October 9, 2024

**Re: Cactus Patch Plaza at 7801 La Morada Pl.
Erosion and Sediment Control Plan
Engineer's Stamp Date 10/7/24 (H10E034)**

Based on the information in your submittal received on 10/7/24, the above-referenced ESC Plan can't be approved until the following comments are addressed.

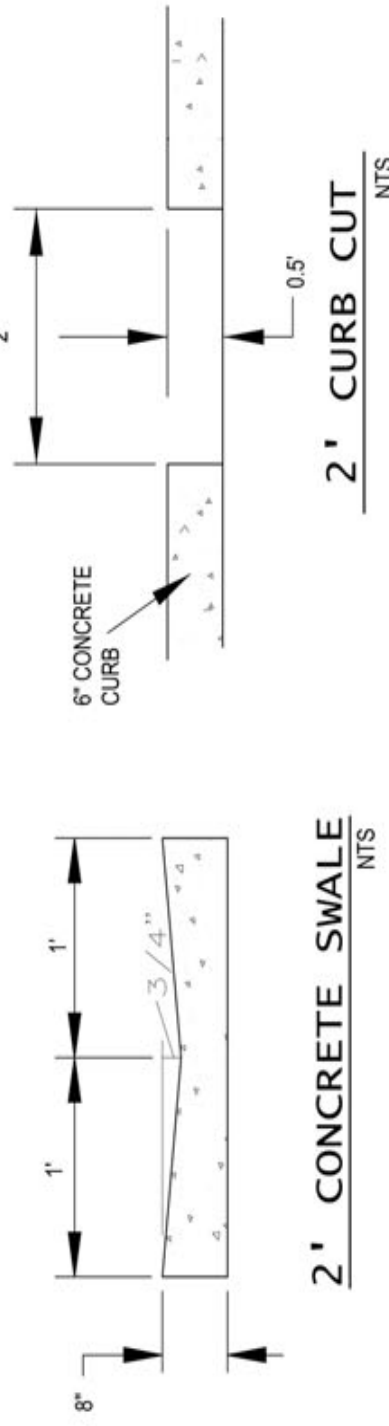
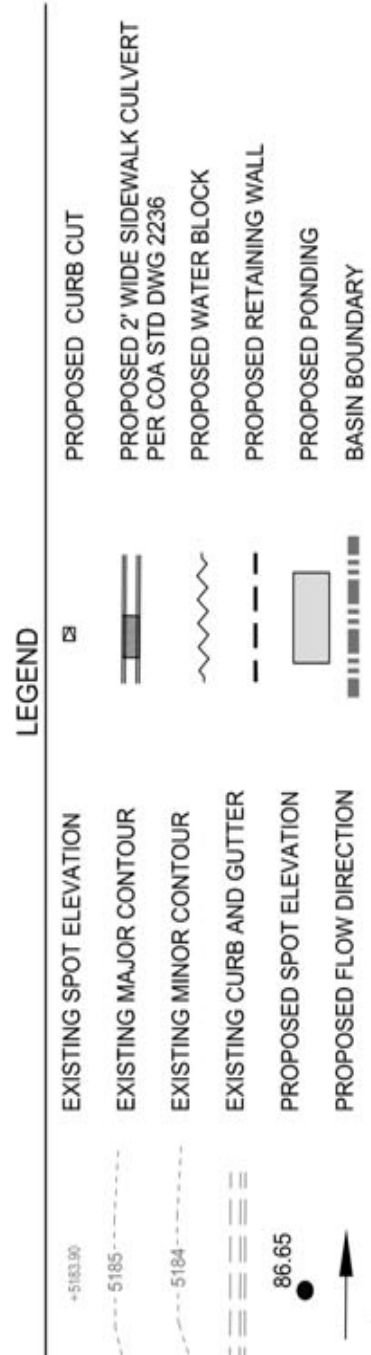
4. The ponds on the ESC Plan page 5 are all retention ponds (without an outlet), so the description as a detention pond on sheets 6, 8, 13, and 18, is inaccurate and must be revised to a retention pond or Sediment Trap. A Sediment Trap detail with construction and maintenance specifications as required. It must withdraw excess runoff from the surface in strict compliance with CGP 2.2.12.
